ENFIELD INTERMODAL (MP05_0147) - PRECINCT E ARCHITECTURE PLAN SIGN OFF - CONDITION 1.8

I refer to the below Precinct E plan which the Department approved pursuant to Condition 1.8 of the Enfield Intermodal consent on 6 March 2020.

Figure 2 - Updated Precinct E plan for DPIE review / approval

1 E2 SITE & FLOOR PLAN.

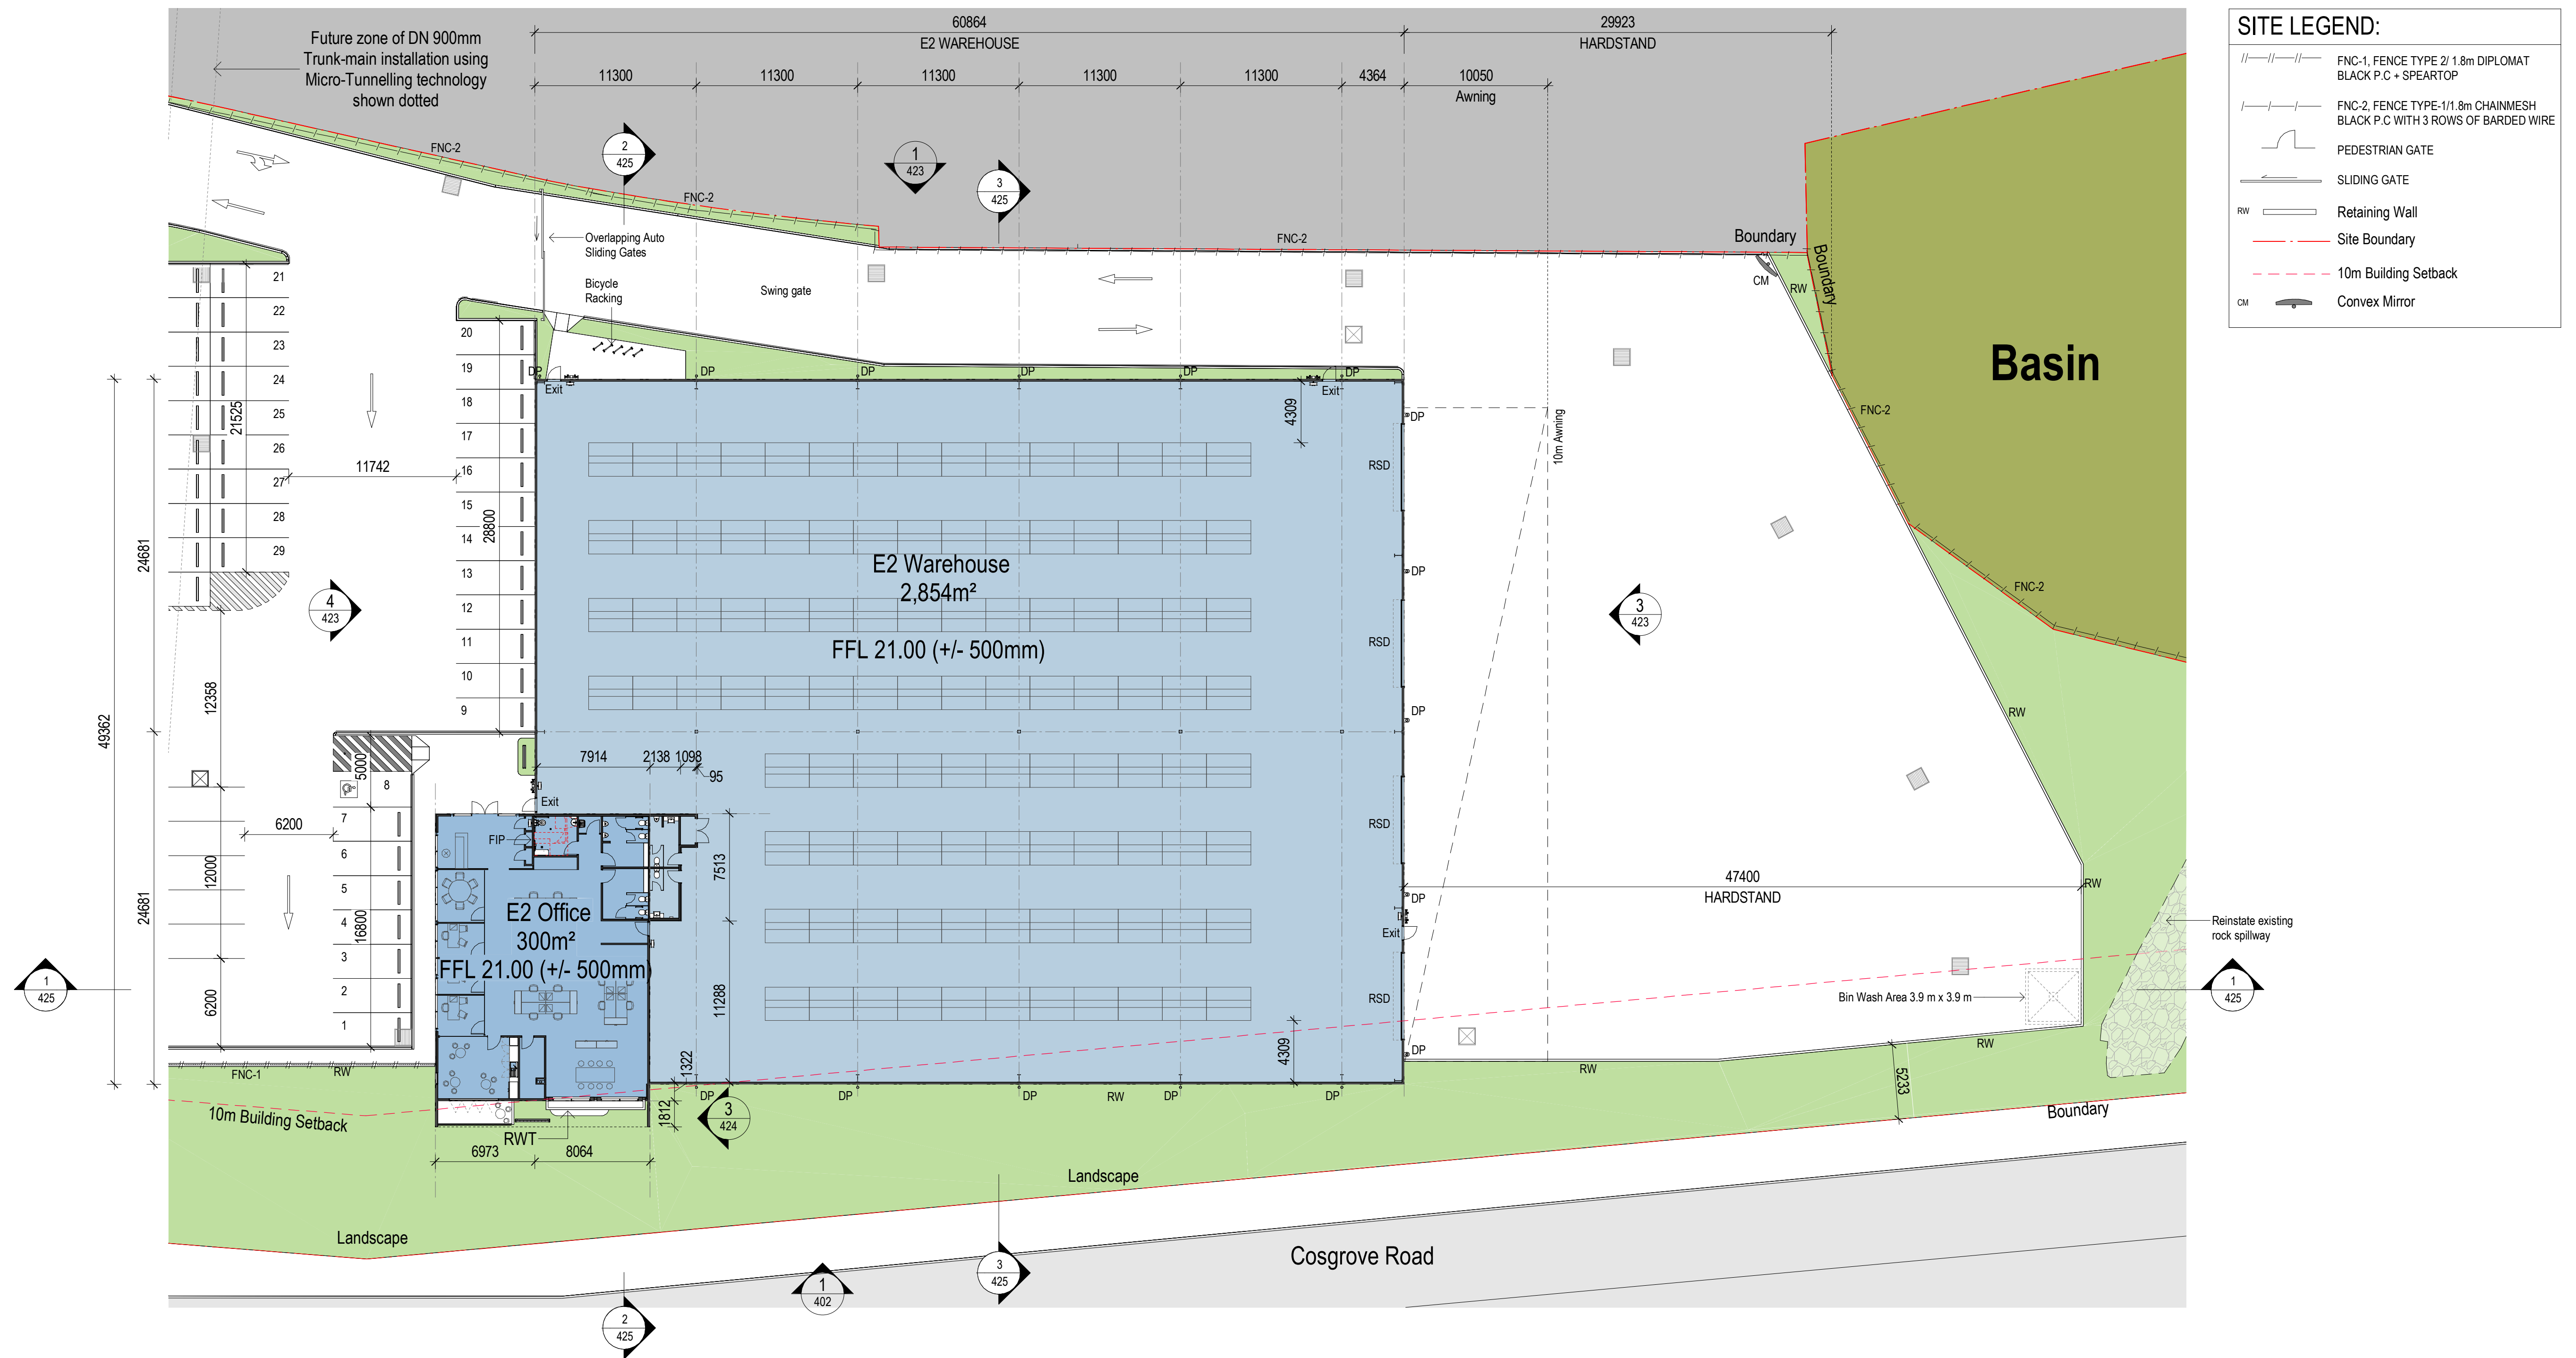
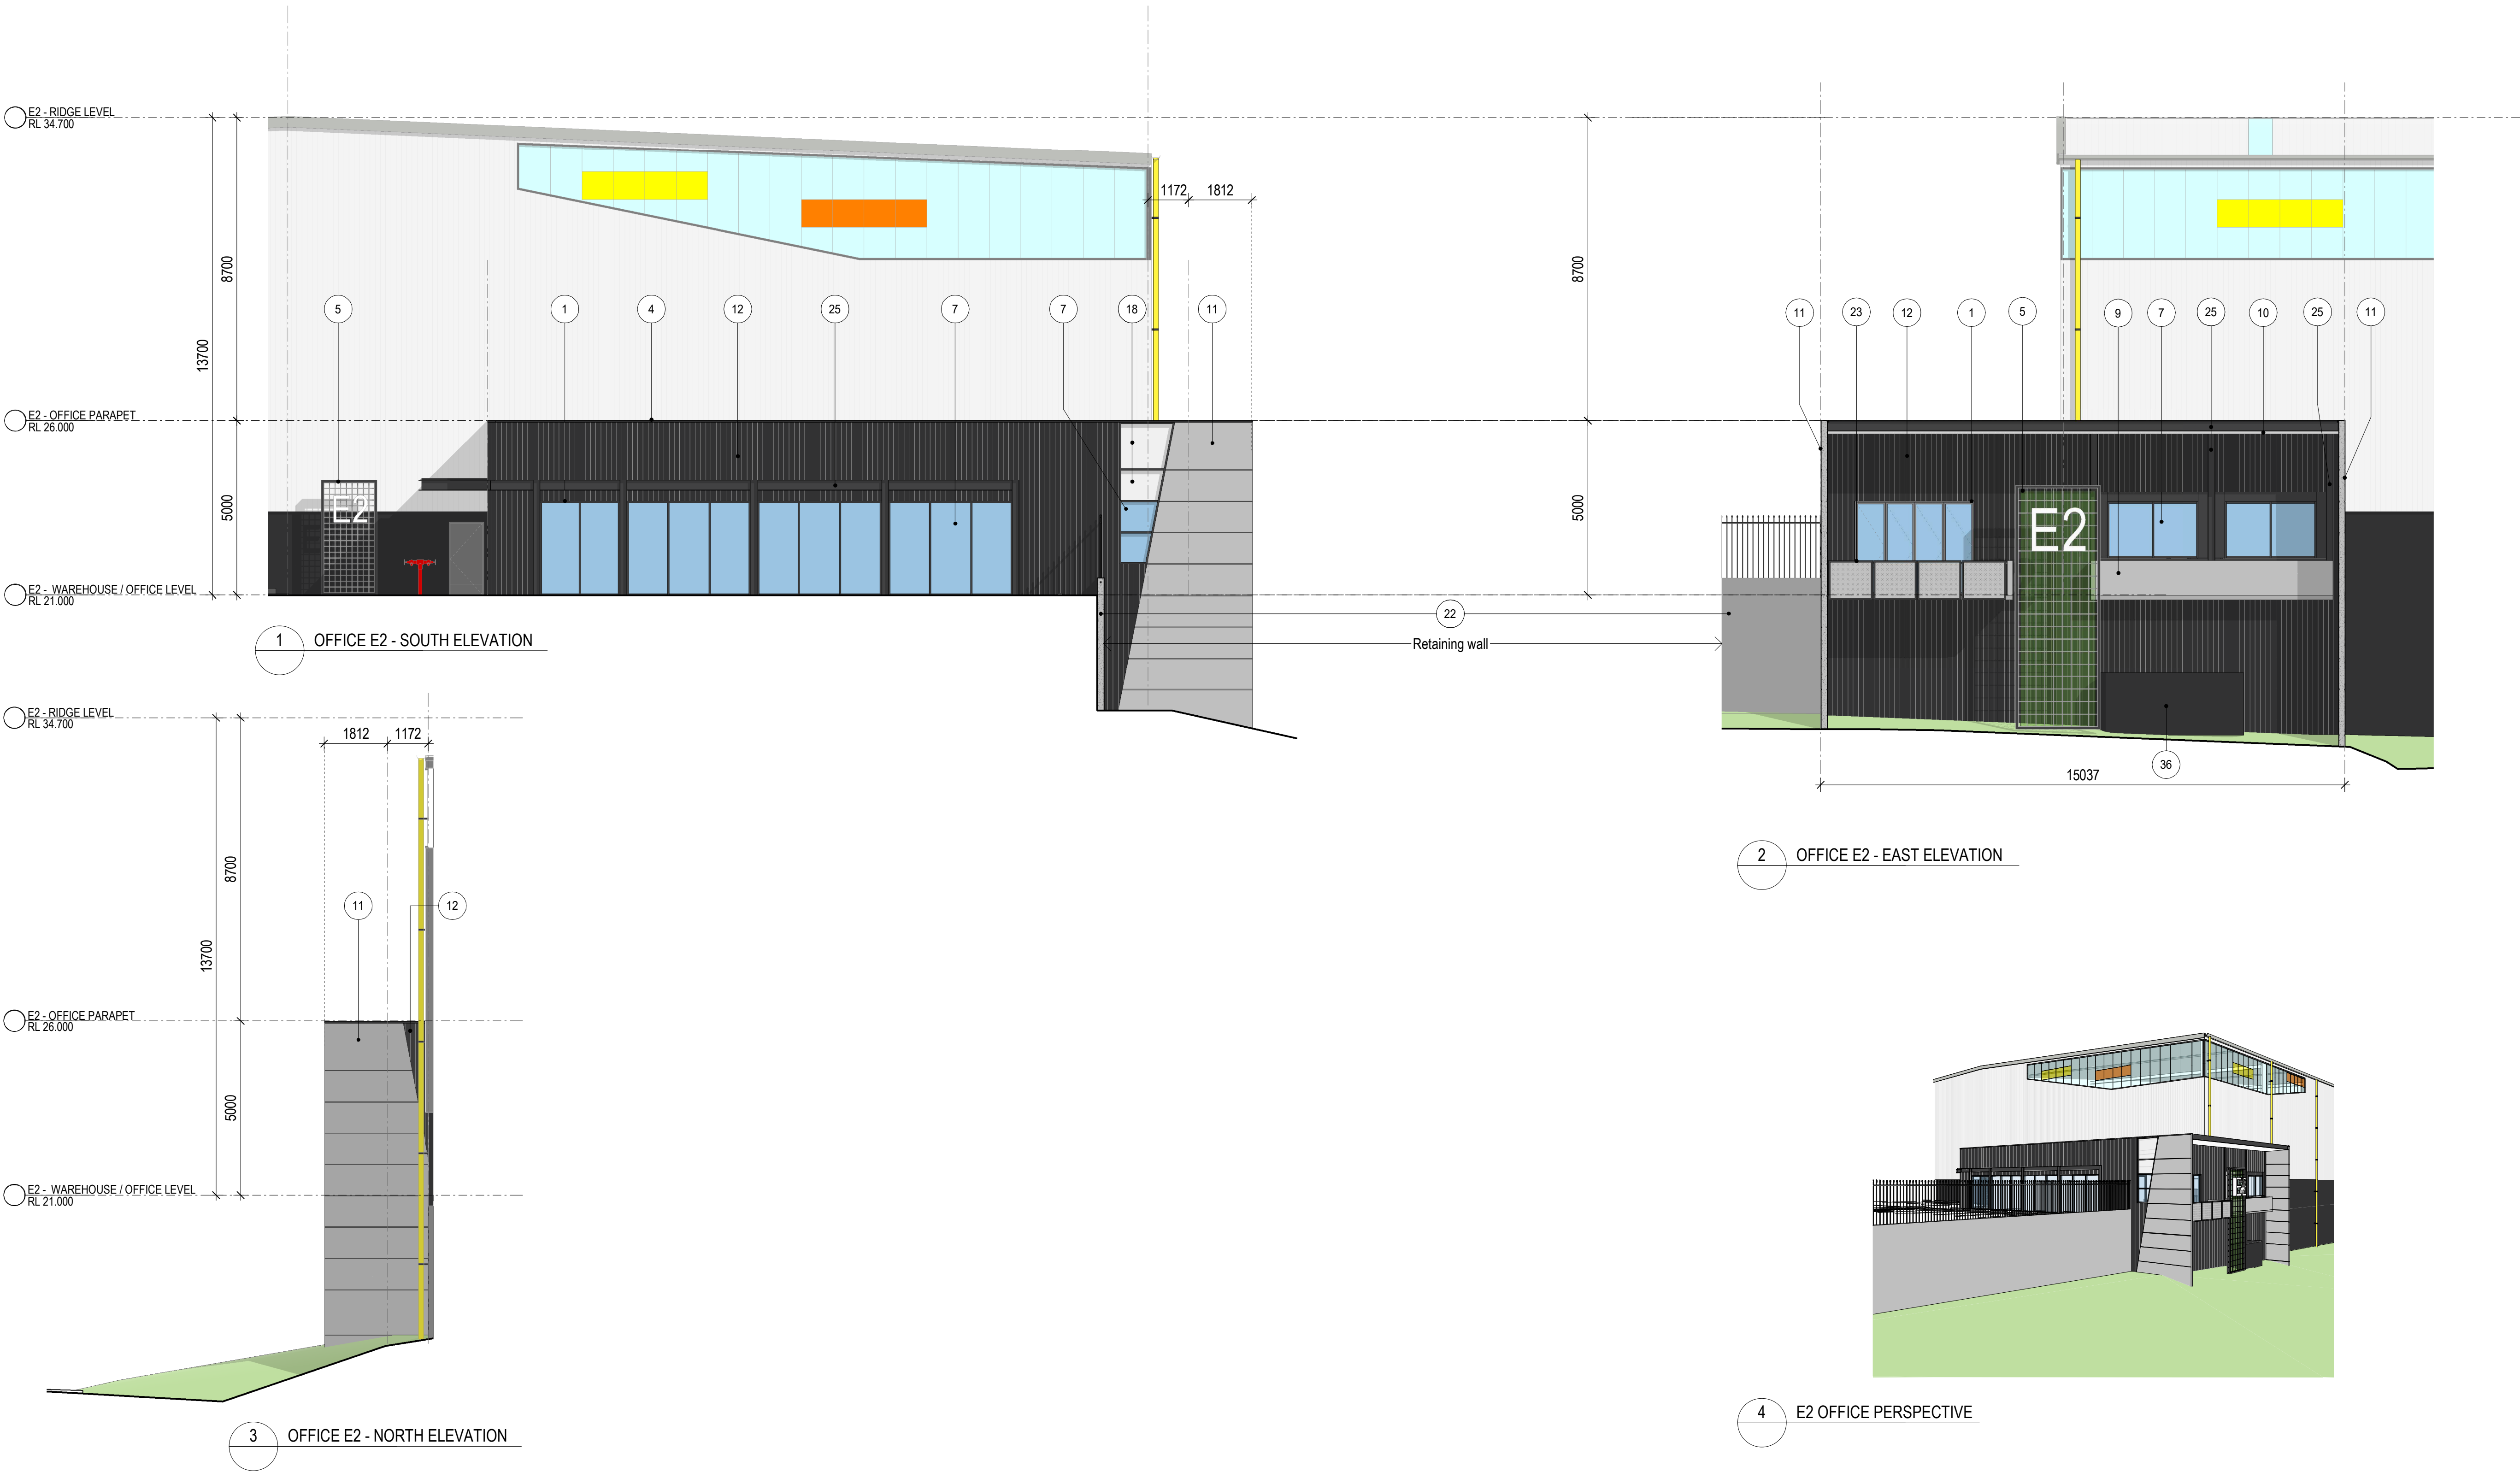
Warehouse E2

- 4) Two (2) new recessed docks added
- 5) Awning increased from 10m to 15m
